Our Case Number: ABP-314724-22

Re: Railway (Metrolink - Estuary to Charlemont via Dublin Airport) Order [2022]
Metrolink. Estuary through Swords, Dublin Airport, Ballymun, Glasnevin and City Centre to
Charlemont, Co. Dublin

Observation on a Strategic Infrastructure Development Application

# COLLINS AVENUE STATION

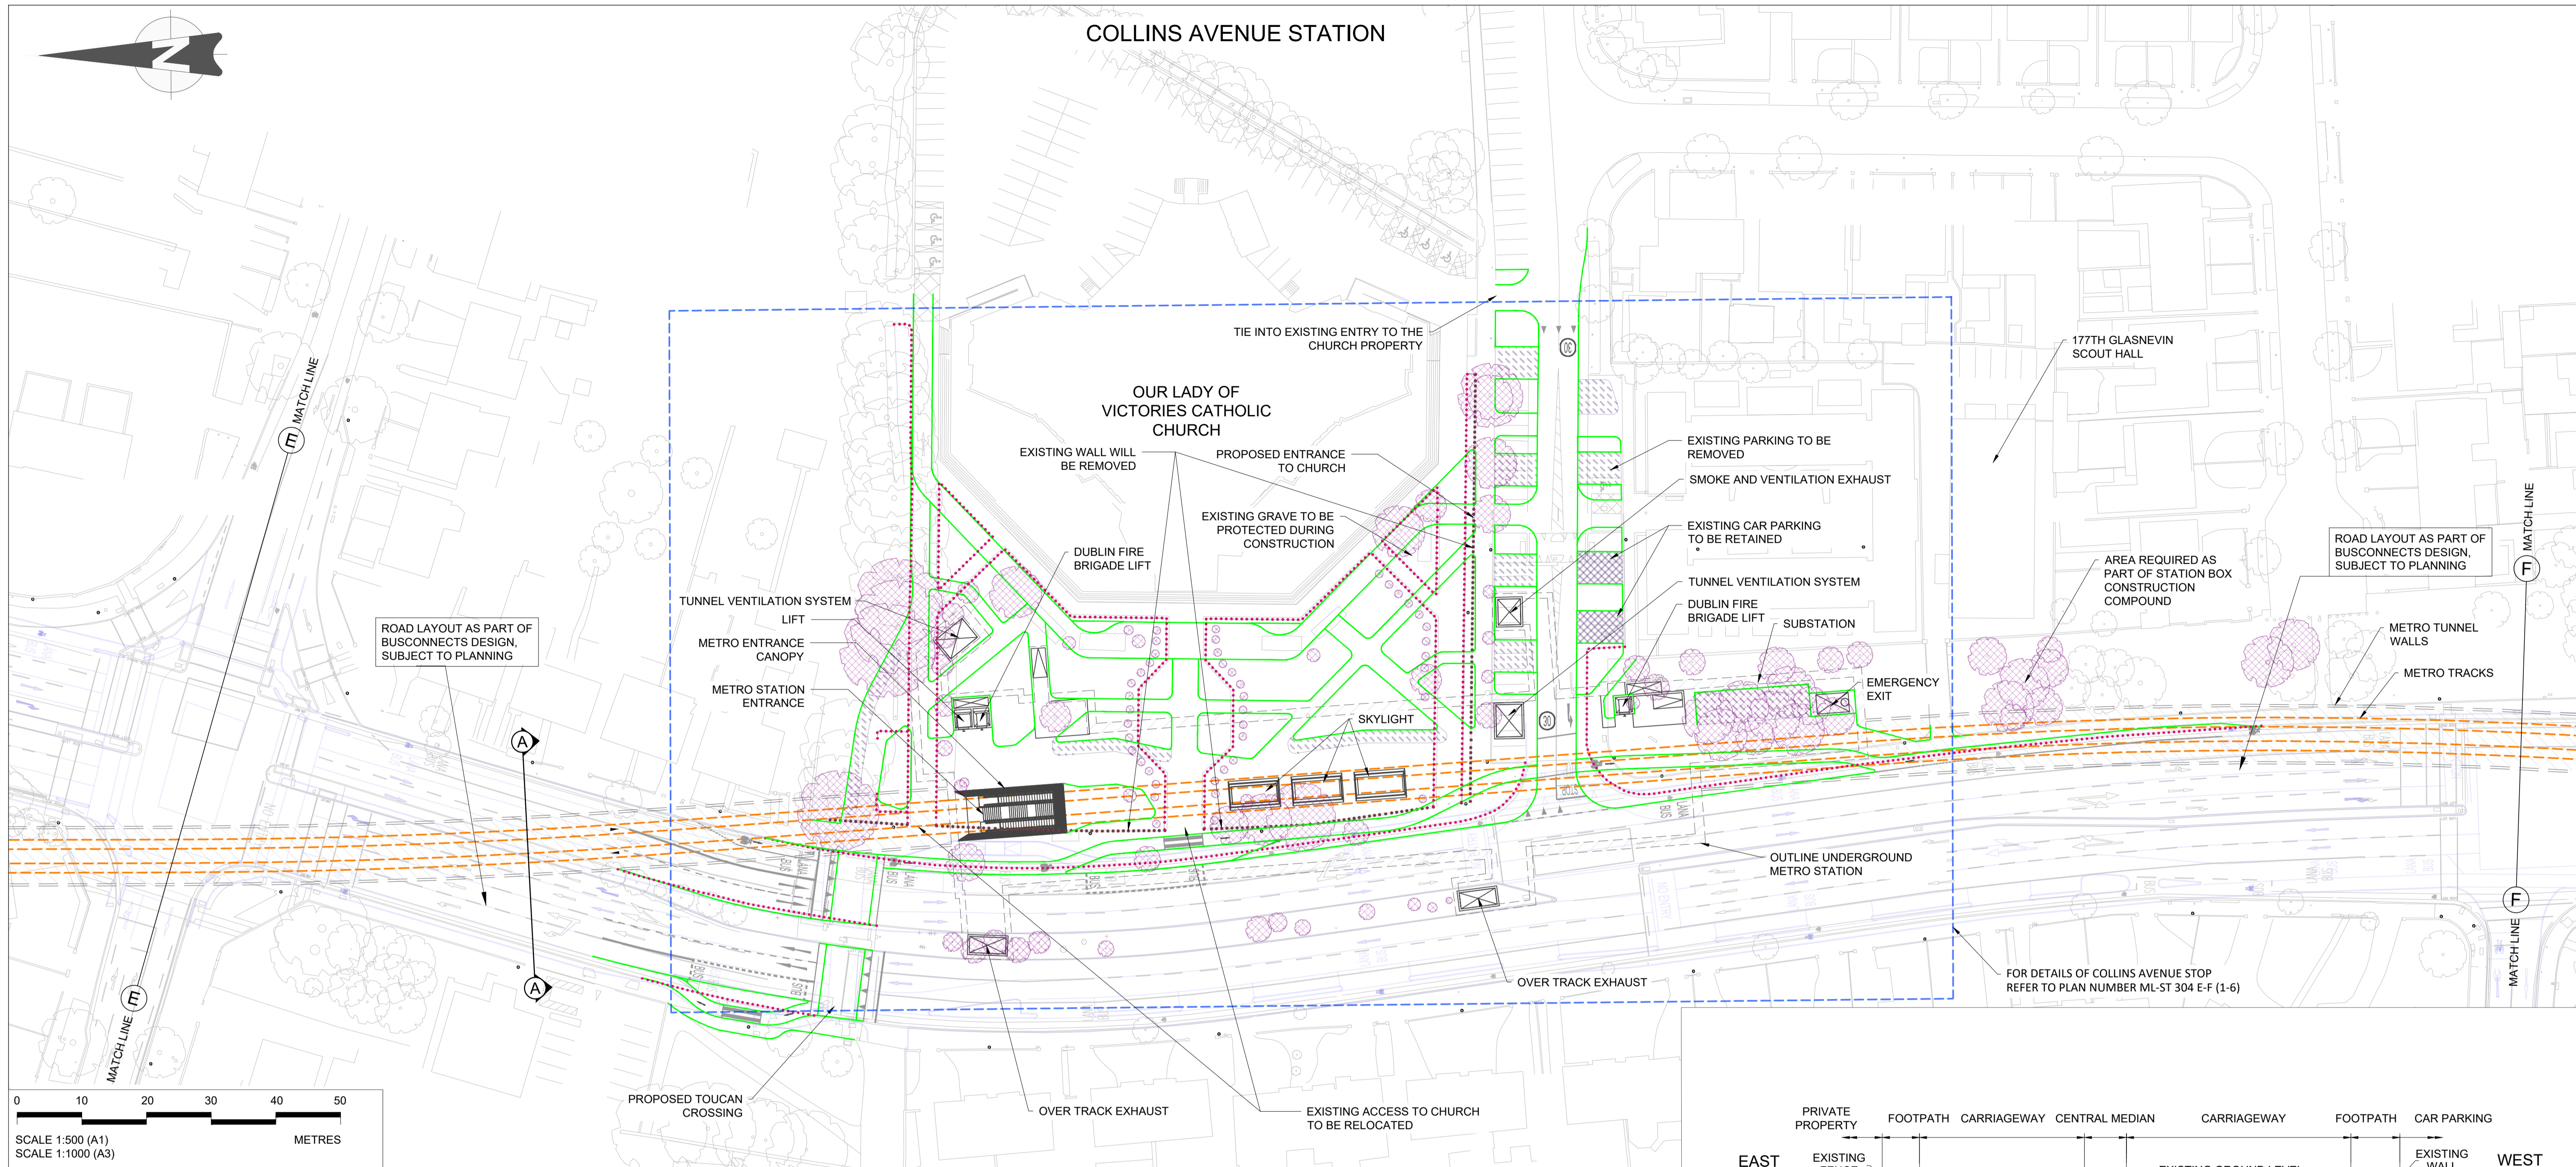
4. Provide more station entrances

The single entrance to most of the stations may look good on paper but the aesthetics will be lost on anyone who has to walk the length of the station in the rain or, as at Collins Avenue and O'Connell Street, wait in the rain to cross a four-lane road to be able to get to the station entrance. Even the single entrance to the Mater station is located as far as possible from the hospitals that the station is meant to serve.
